**Subject:** RE: Planning Consultation on: R/53/22/DOC

#### **Engineers Comments Regarding Surface Water Drainage**

**Application No:** R/53/22/DOC

**Description of Works:** Approval of details reserved by condition imposed under ref R/187/16/PL relating to Condition Nos 13 - provision to prevent surface water discharging to public highway, 19 - foul and surface water sewerage disposal, 20 - surface water drainage and 22 - maintenance and management of SuDs system.

11659/1902

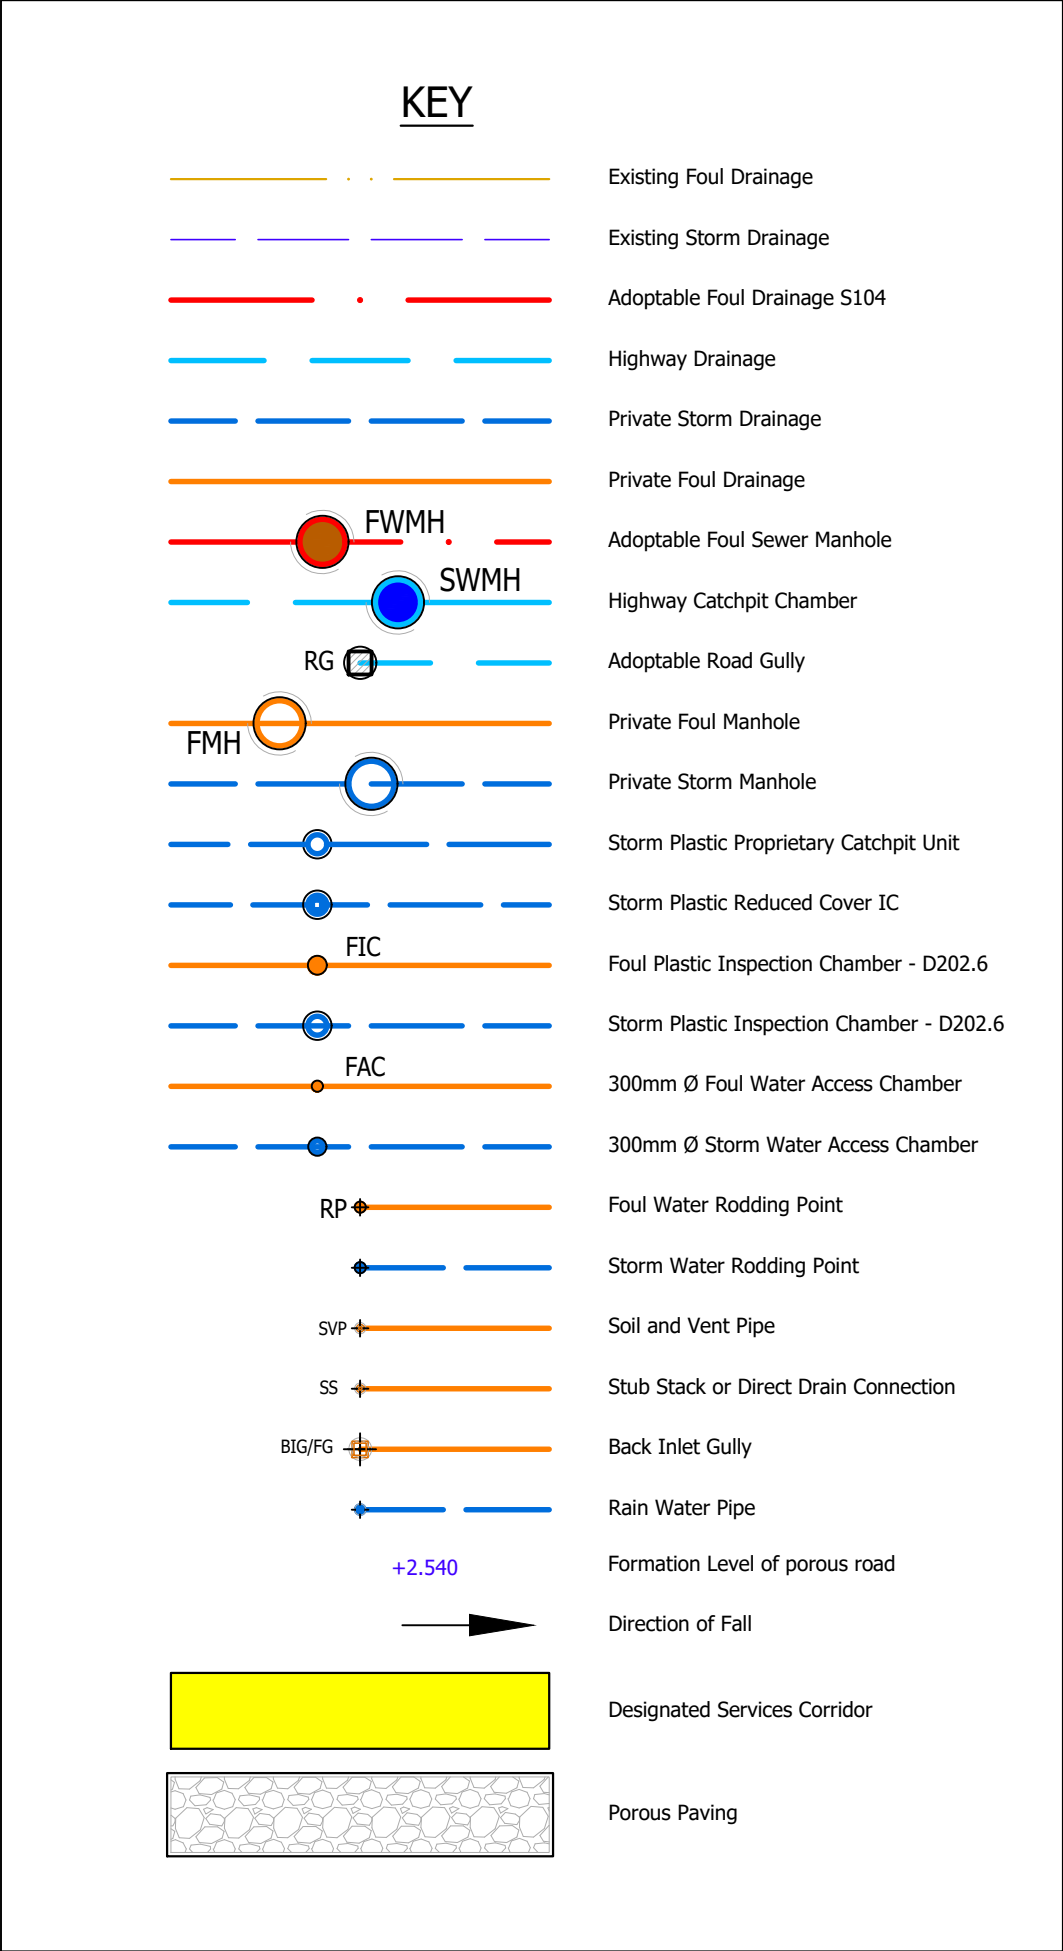
1. A full detailed drainage design including long sections, and details for all elements of the scheme has not been provided. This design should include the bespoke parts of the drainage system, e.g. showing how the connection to the retained outfall will be removed, and details of the service corridors and underdrains beneath the permeable paving (not just standard details).

- g) Details of how the permeable surfacing and sub-base will integrate with any areas of no dig construction associated with the arboricultural constraints and mitigation strategy identified at planning.

- The root protection zones, and tree protection plan identified and proposed at the planning stage, do not appear to have been included within the final drainage design. It will be necessary to ensure the design takes into consideration the existing trees in accordance with the arboriculture constraints.
- A 5m easement between the permeable paving and any buildings will be required. This is considered necessary as there is a high percentage of impermeable area draining to the permeable paving zones (where infiltration is possible). This will result in the system concentrating runoff in a relatively small/confined area.

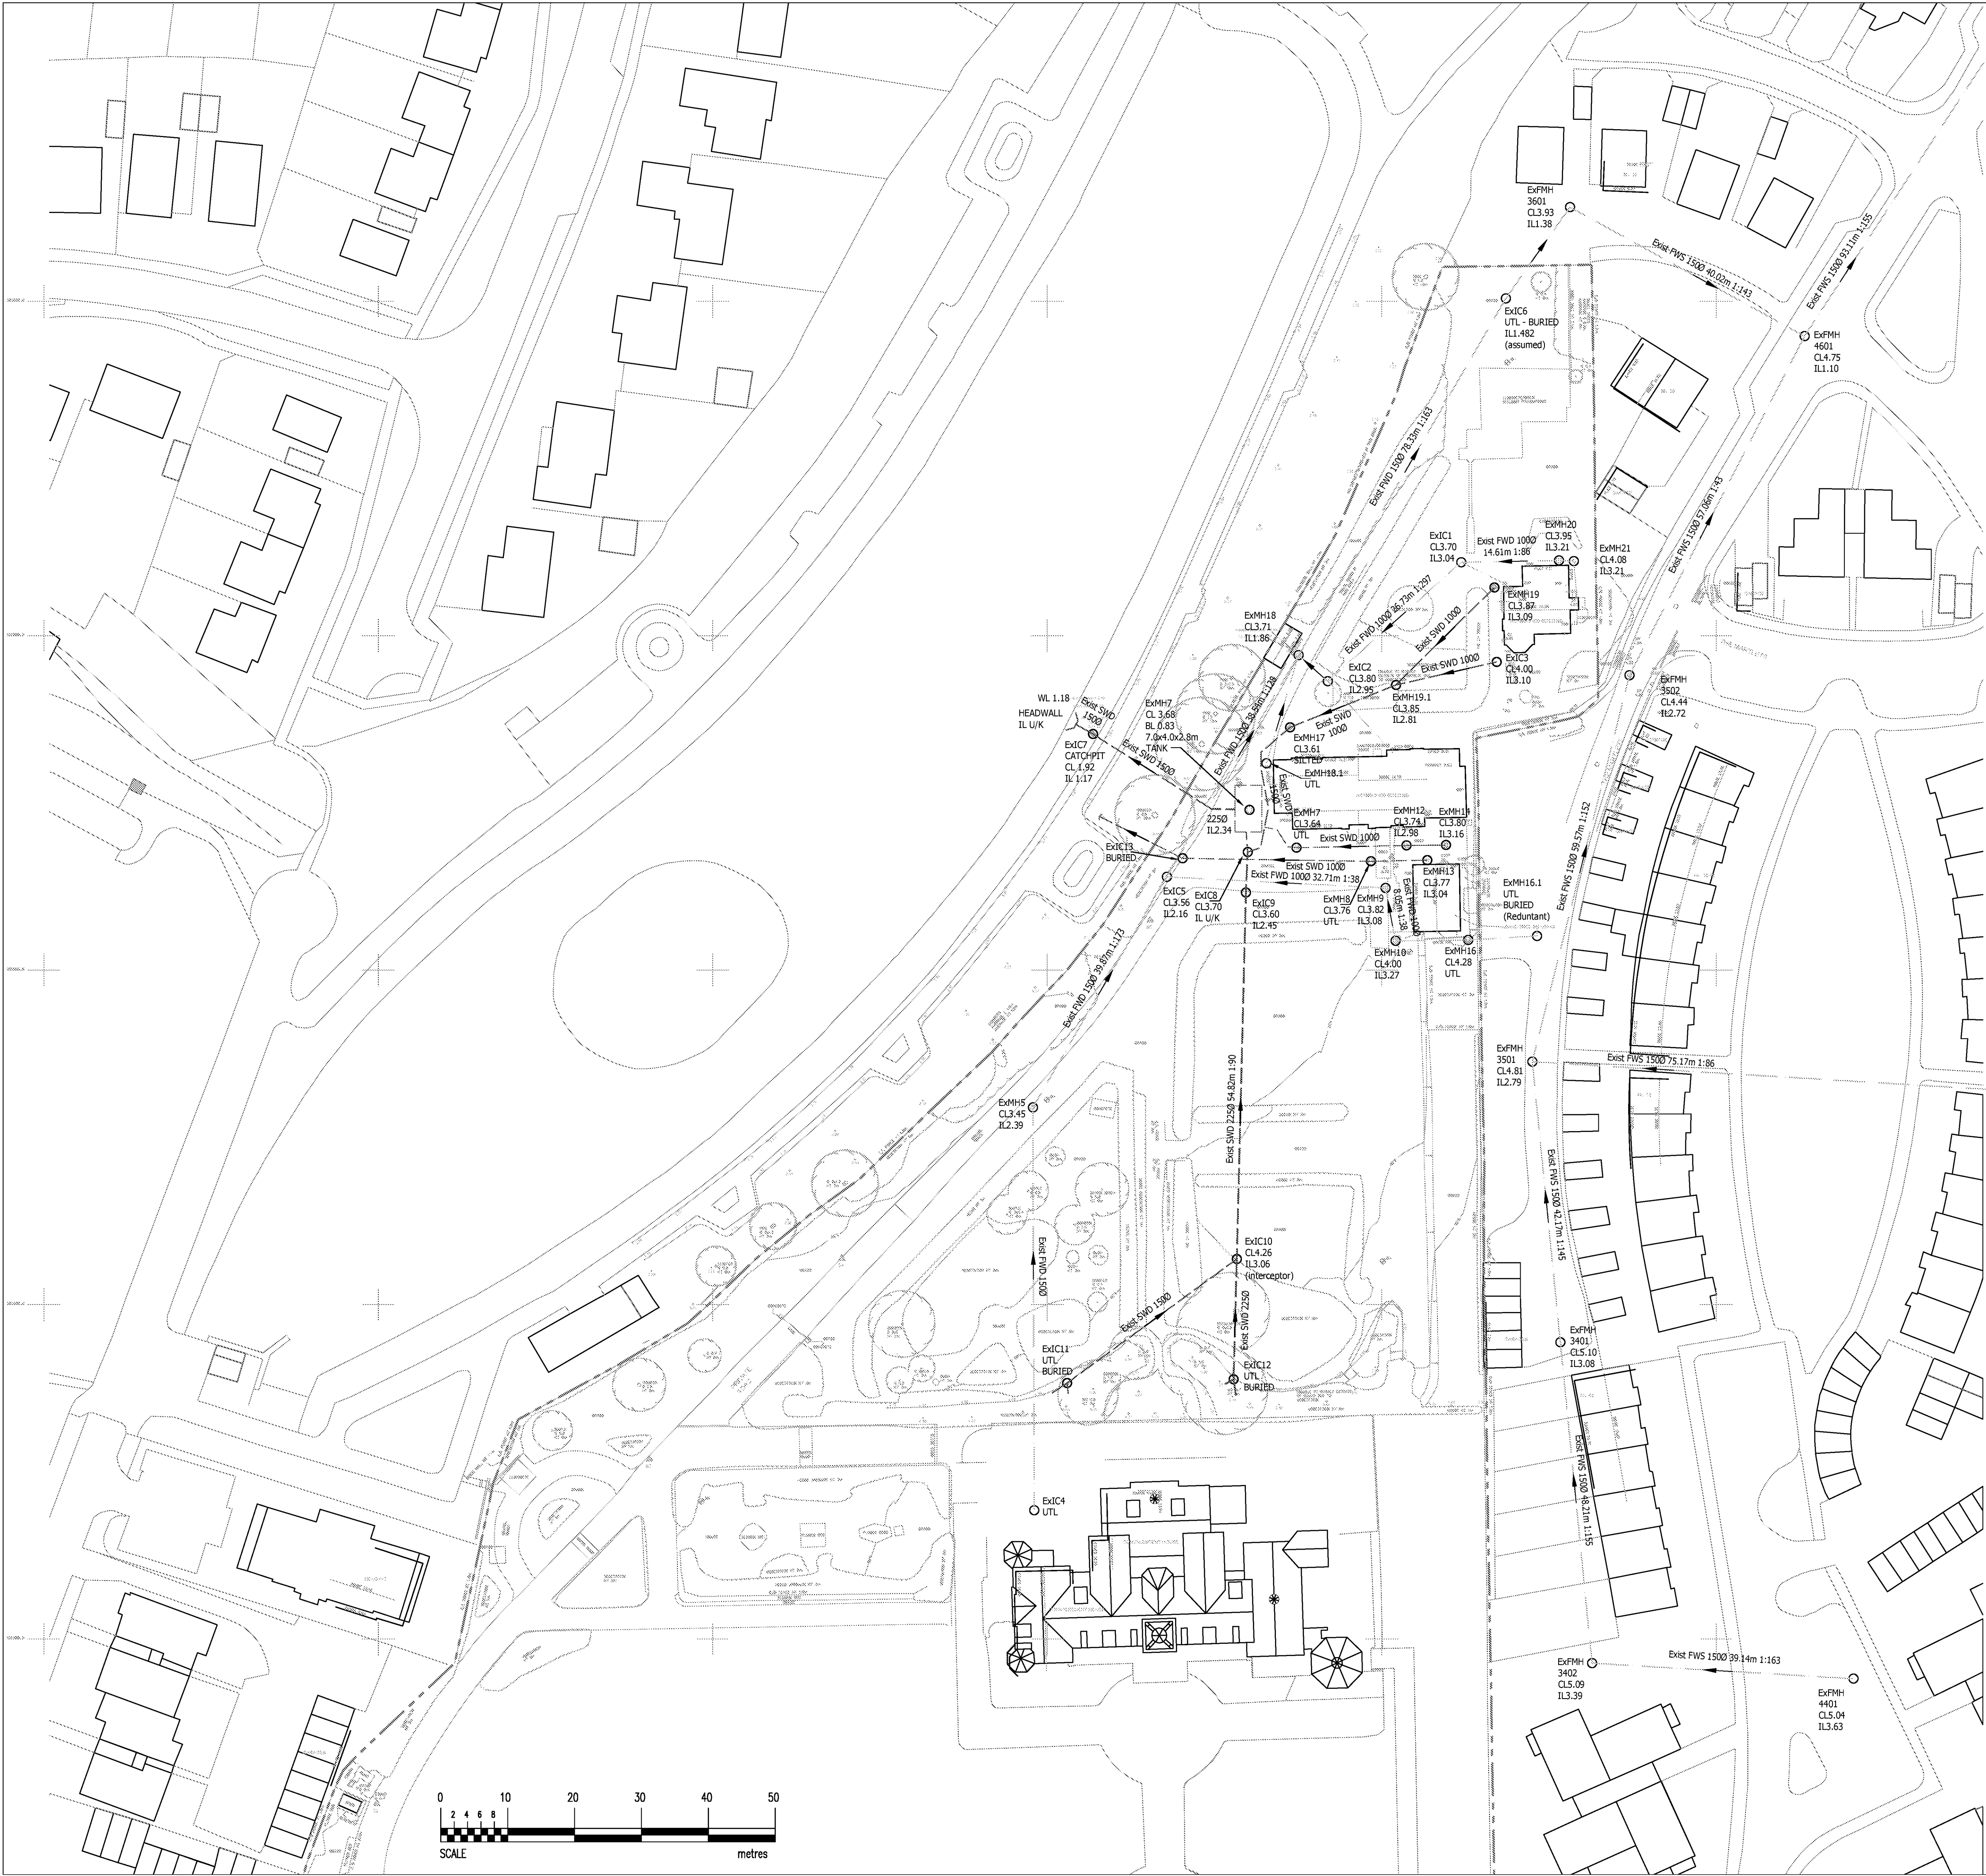
5. Further information on the existing drainage is required, as there are still some unknowns which could have a significant impact on the constructed design. In particular the following points should be addressed:

- At approximate grid reference TQ 04367 01504, there appears to be a set of garages (offsite) which drain onto the development site, potentially freely via a disconnected downpipe. The exact nature of the drainage in this area should be confirmed to identify the area which is drained through the site. You will not need to include these additional flows within your drainage calculations / sizing of the proposed SuDS if it can be demonstrated that this area is relatively small and is unlikely to result in regular flooding, or a hazard to site users.

- At approximate grid reference TQ 04372 01552, the existing drainage drawing shows a manhole with inflows from the north, potentially indicating the adjacent carparking area drains through the existing site. As this drainage run is to be removed as part of the proposals, it is necessary for this to be surveyed and for any flows from the carpark (offsite) to be managed. This is to ensure that the risk of flooding is not increased. As with the previous point, if it is shown that the flows are fairly low, and the risk to the site and surrounding area is minimal, you will not have to incorporate these additional flows into the SuDS storage calculations.
